MORGAN AND MORECAMBE OFFSHORE WIND FARMS: TRANSMISSION ASSETS

Response to Section 51 advice

December 2024

Document reference: S_S51_1

Drawing Number:
BP-GBR-MORG-REG-0183

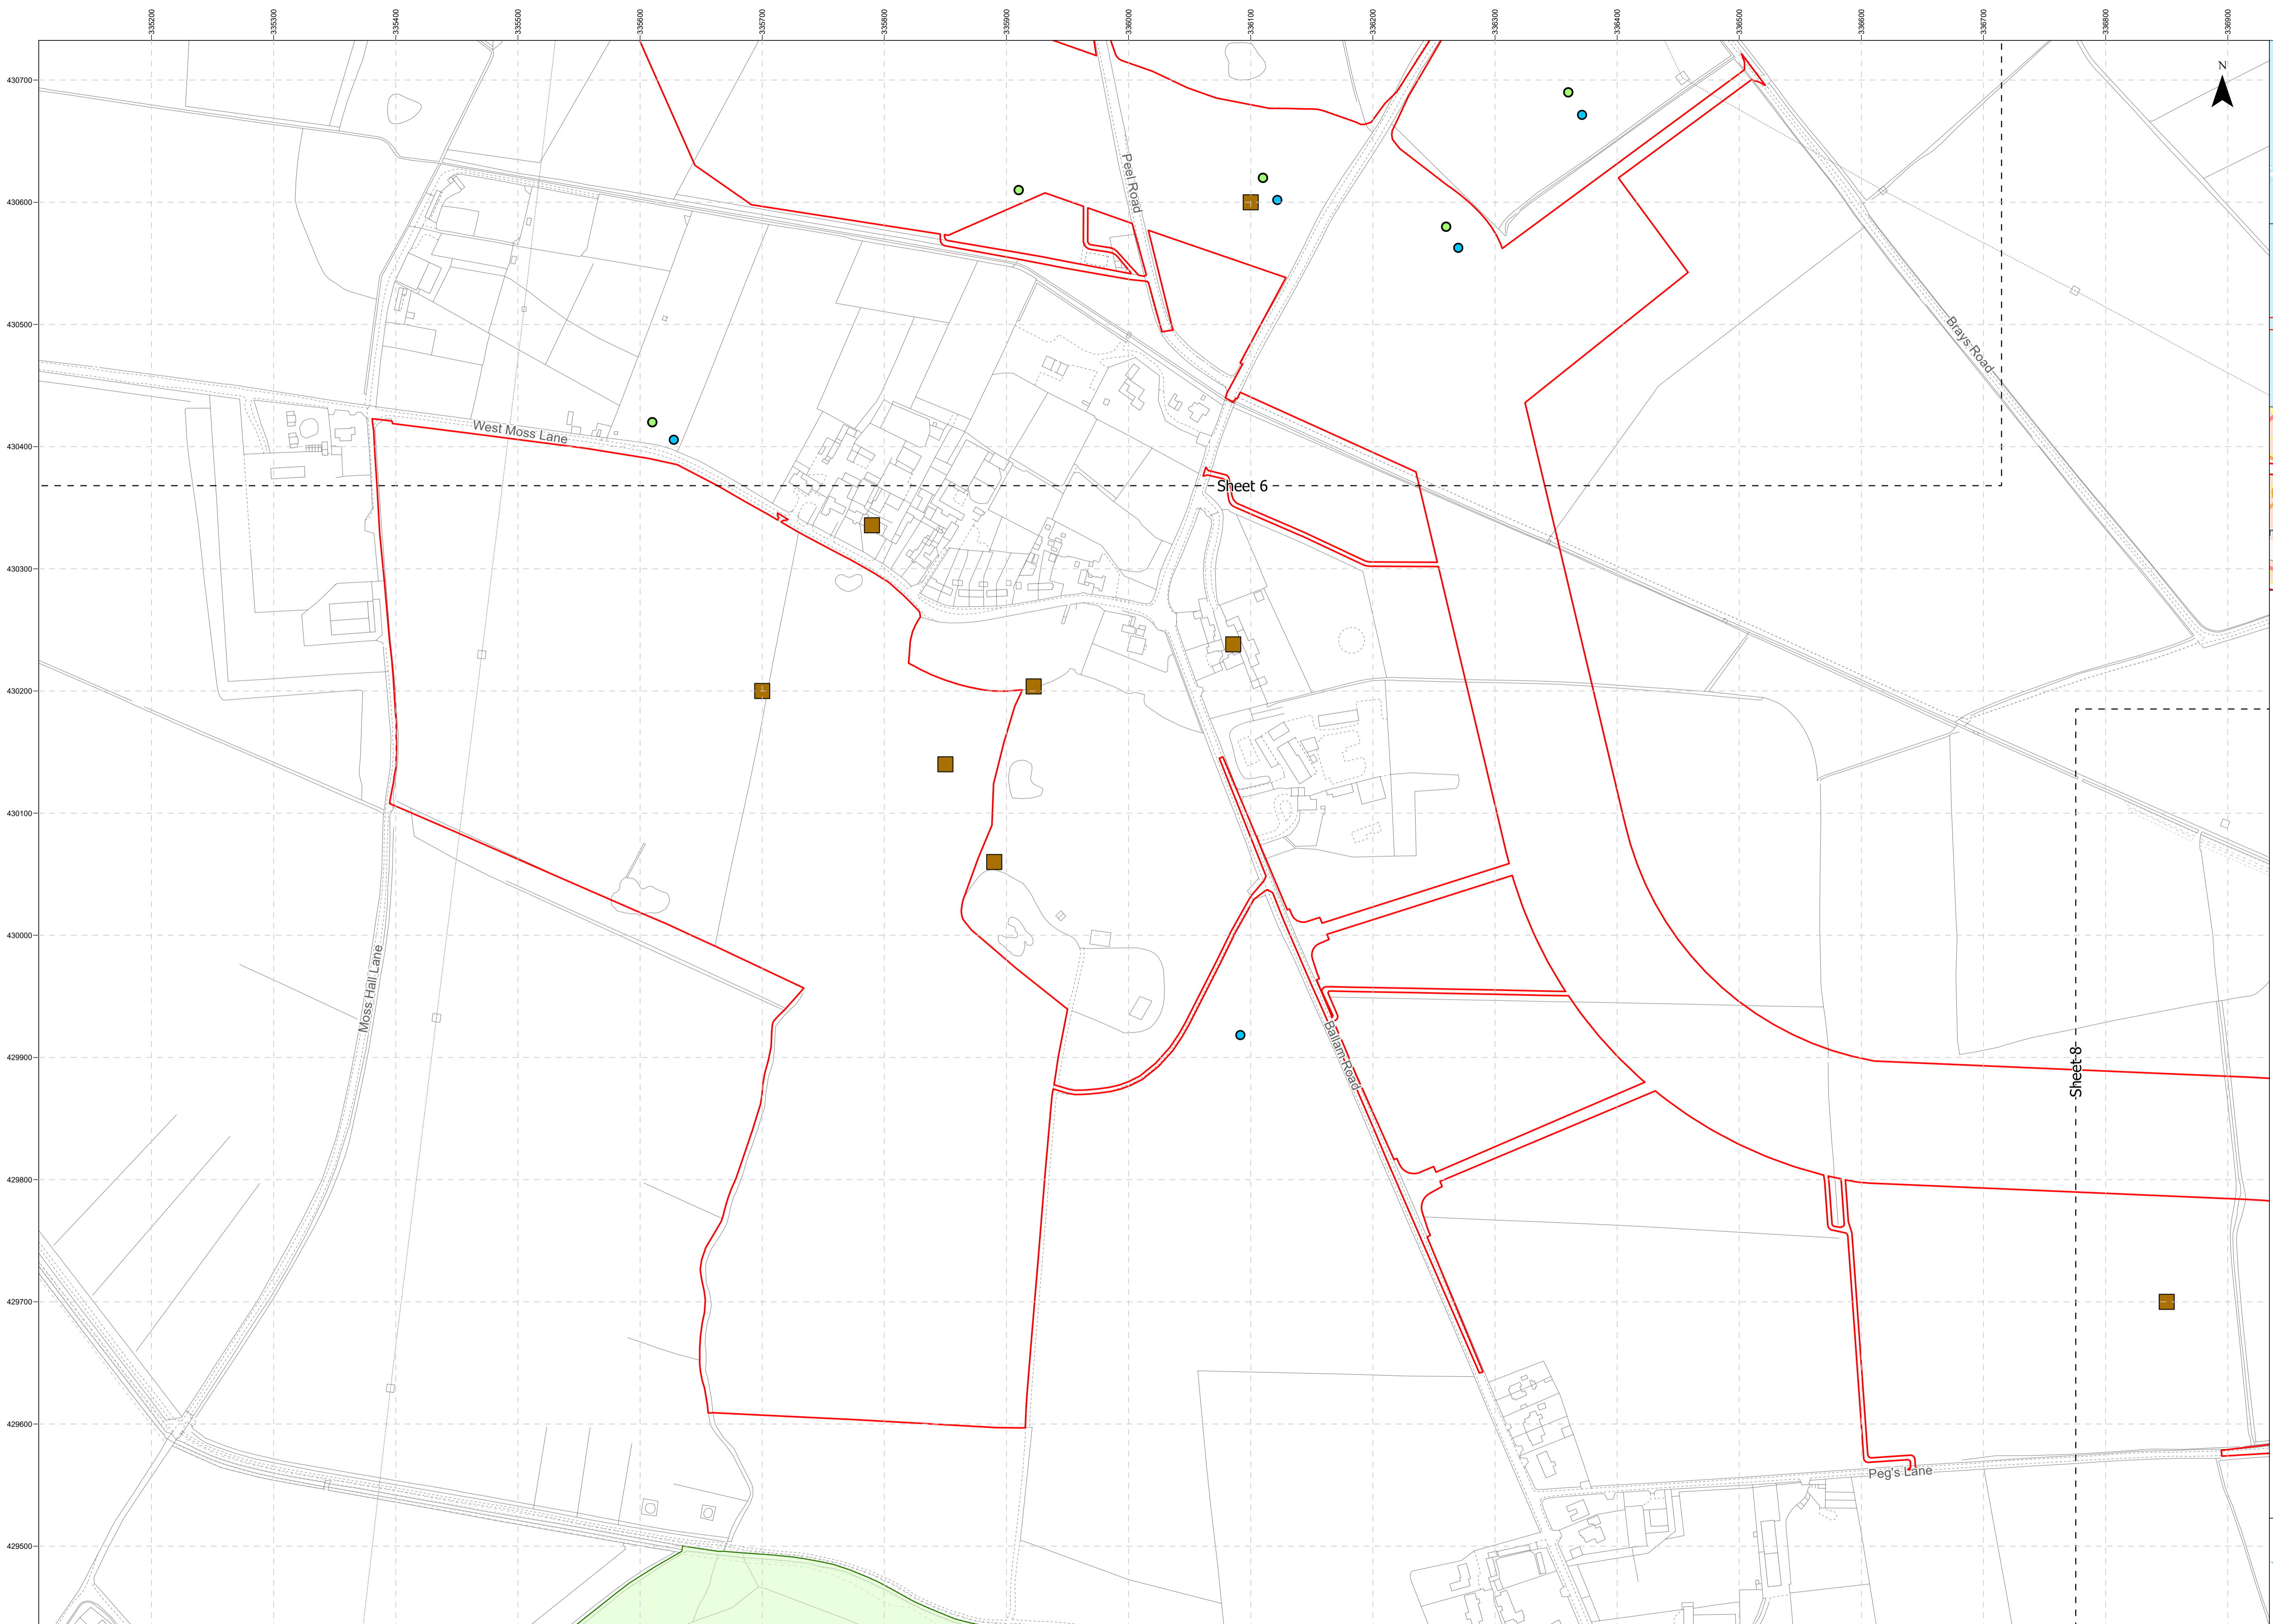
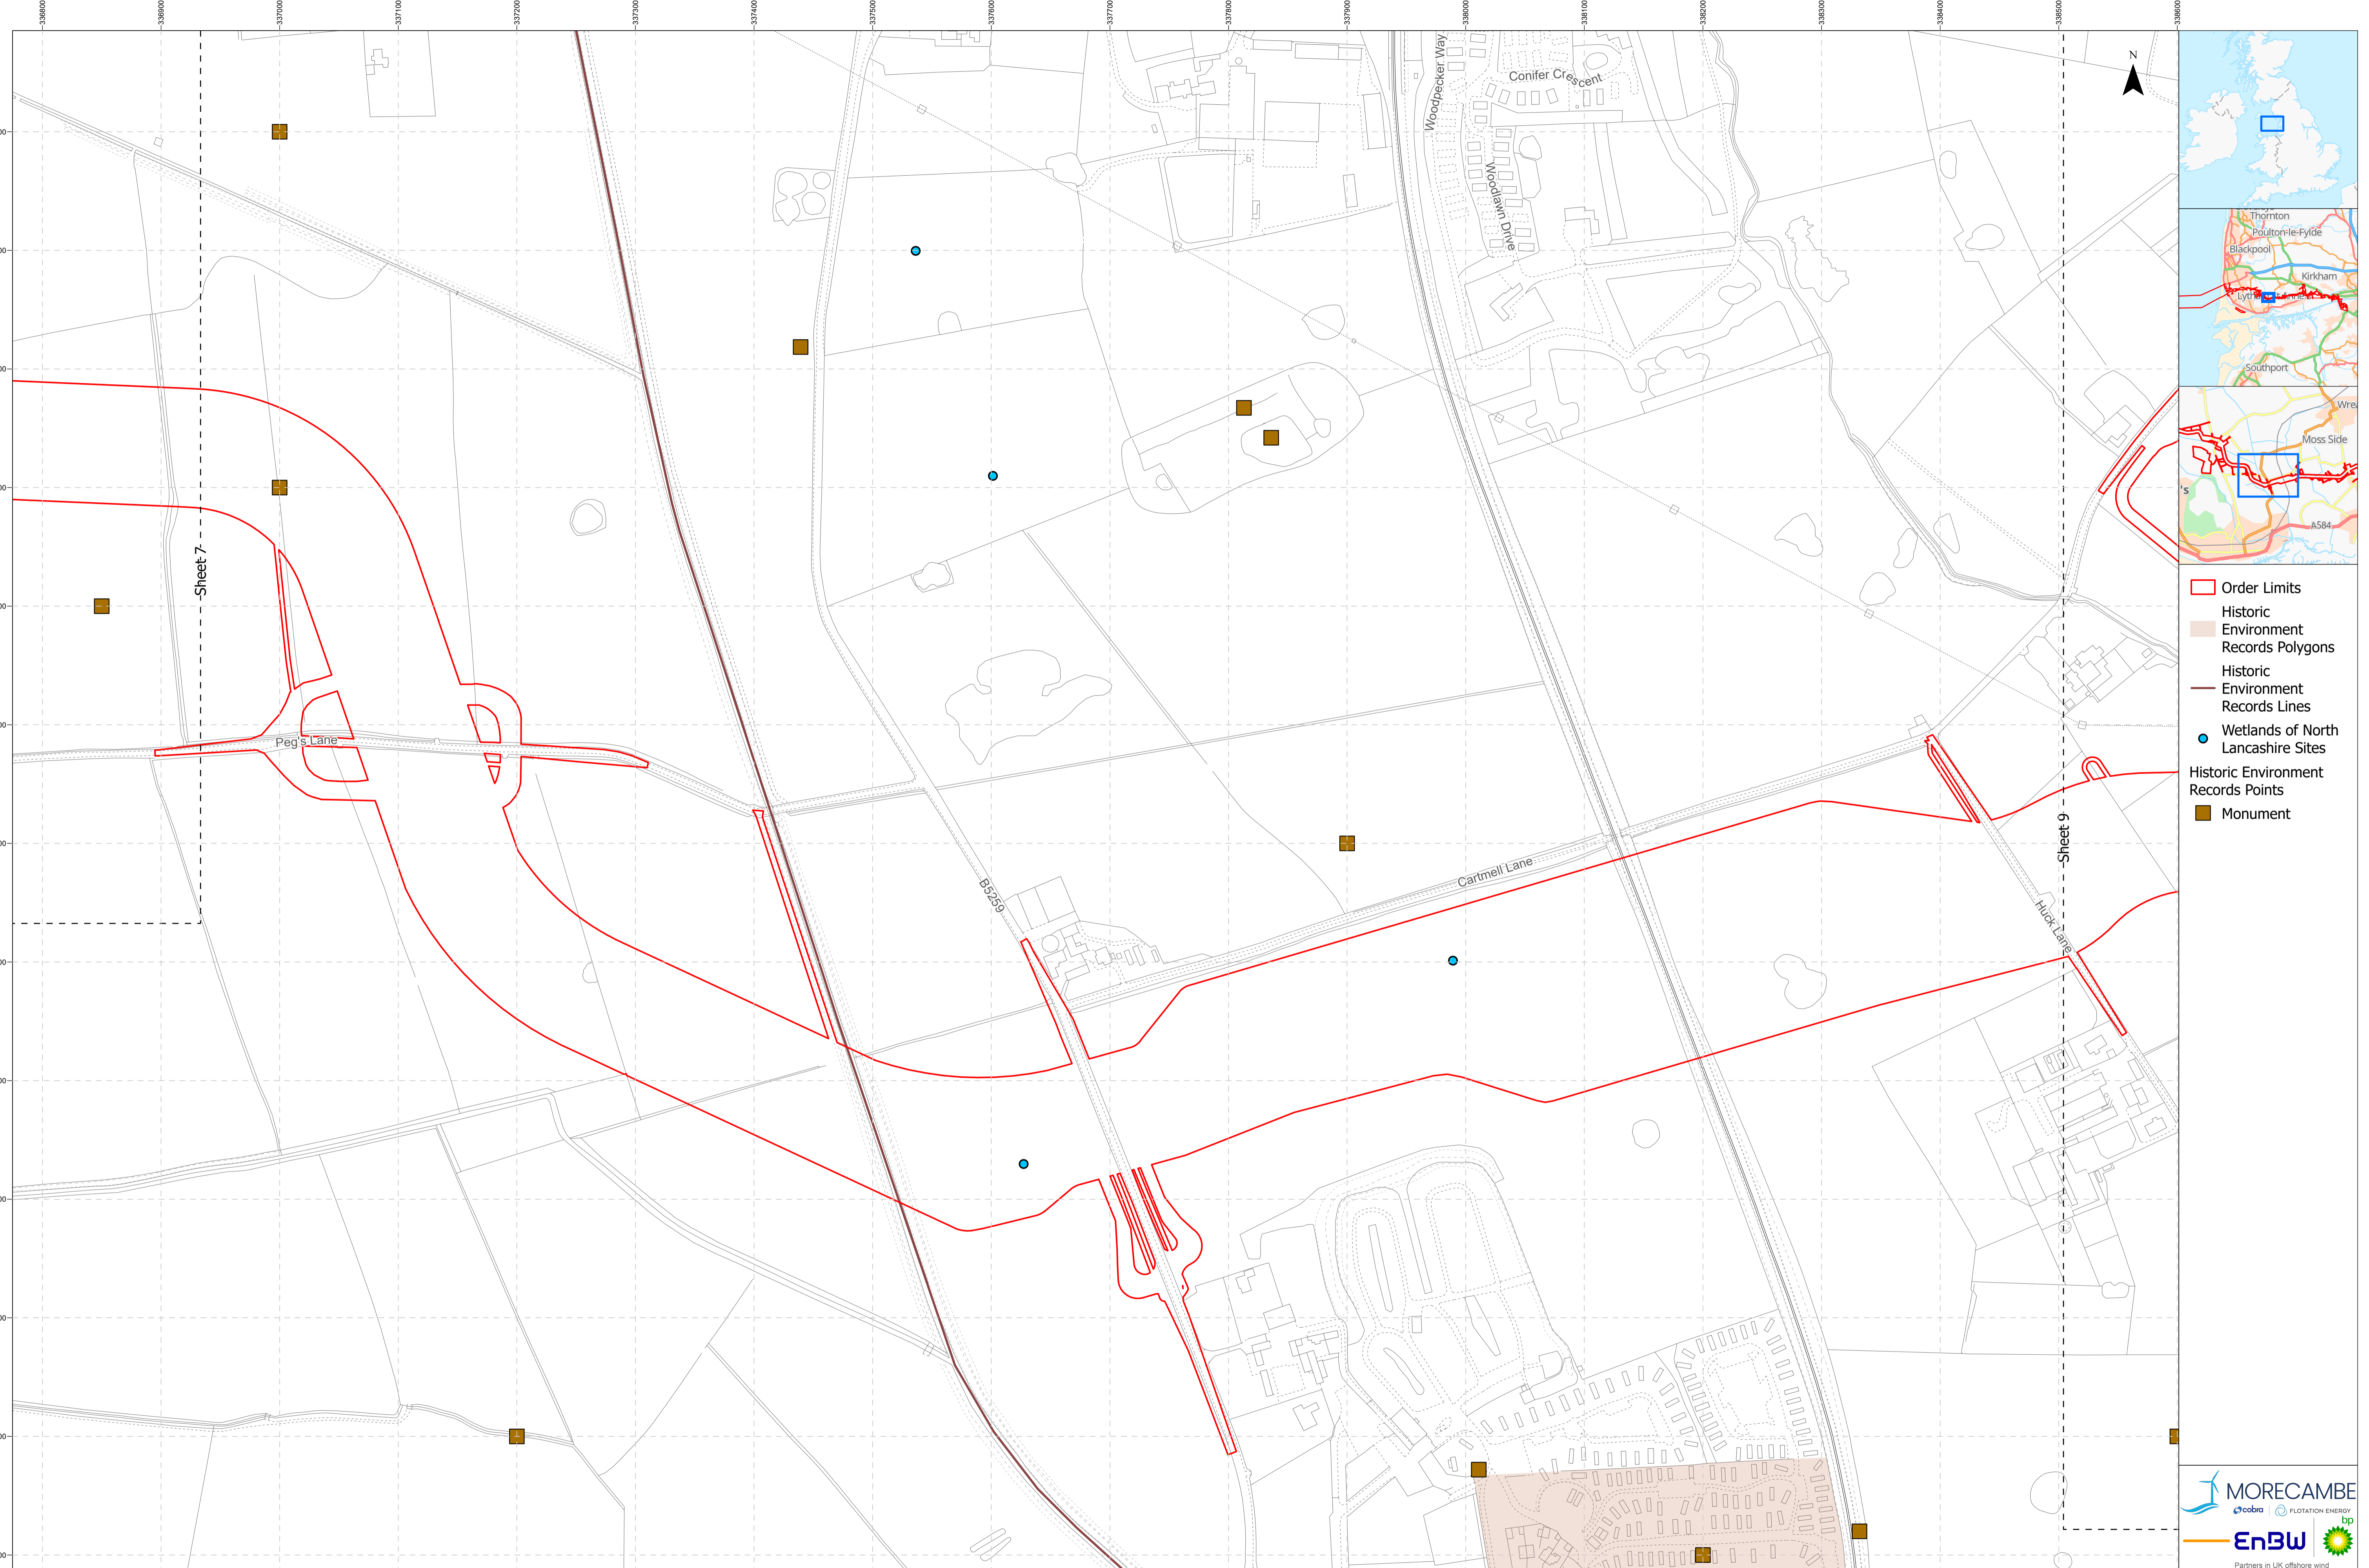
Onshore Statutory and Non-Statutory Nature Sites and Onshore Historic or Scheduled Monument Sites	<p>“The plans showing Onshore Statutory and Non-Statutory Nature Sites (and Waterbodies in a River Basin Management Plan) (Doc B14) and Onshore Historic or Scheduled Monument Sites (Doc B16) present the sites, rivers or historic assets, however these are not labelled (unlike the equivalent offshore plans). The Applicants are advised to provide an updated set of figures with appropriate labelling of the features being represented. “</p>	<p>The Applicants have updated this document with the requested changes and have submitted it to the Planning Inspectorate (document reference: B14/F02 and B16/F02). Both documents contain a Schedule of Changes.</p>
Onshore Historic or Scheduled Monument Sites	<p>Between the onshore historic or scheduled monument sites (Doc B16) and ES Volume 3 (Doc F3.12, figures for chapter 5), there appear to be some minor differences in terms of the specific assets recorded between these drawings. An example is Doc F3.12 ES figure 5.7 compared to sheet 3 of Doc B16. The Applicants are advised to provide an updated set of figures which are consistent in the features being represented, with appropriate labelling.</p>	<p>The Applicants have reviewed the Onshore Historic or Scheduled Monument Sites plan alongside the Environmental Statement (ES) Volume 3 Figures and can confirm that the data included is the same. However, the data shown on the ES figures has been separated based on the time period for the records. To facilitate ease of cross-referencing between the documents, labels referencing the heritage asset list entry have been added to the Onshore Historic or Scheduled Monument Sites plan (document reference: B16/F02). The Applicants have submitted the updated Onshore Historic or Scheduled Monument Sites plan (document</p>

Topic	Section 51 advice	Applicants' response
		reference: B16/F02) to the Planning Inspectorate. The document also contains a Schedule of Changes.
Statutory and Non-Statutory Features of (The Offshore) Historic Environment Plan	<p>“Standalone figure B17 (Statutory and Non-Statutory Features of (The Offshore) Historic Environment Plan) only shows offshore exclusion areas rather than specific features, however the specific sites are shown on the ES figures. The Applicants are advised to provide an updated set of figures with appropriate labelling of the features being represented.”</p>	<p>The Applicants have reviewed the Offshore Historic Environment Plan alongside the ES Volume 2, Figure 8.5 and can confirm that the location of the geophysical anomalies shown as high medium and low are the same.</p> <p>The Applicants have reviewed the Offshore Historic Environment Plan alongside the ES Volume 2, Figure 8.6 and can confirm that Archaeology Exclusion Zone (AEZs) and Temporary Archaeology Exclusion Zones (TAEZs) are the same. To enable cross-referencing between the documents, named wrecks have been added to their corresponding ID reference. The Applicants have submitted the updated Offshore Historic Environment Plan (document reference: B17/F02) to the Planning Inspectorate. The document also contains a Schedule of Changes.</p>
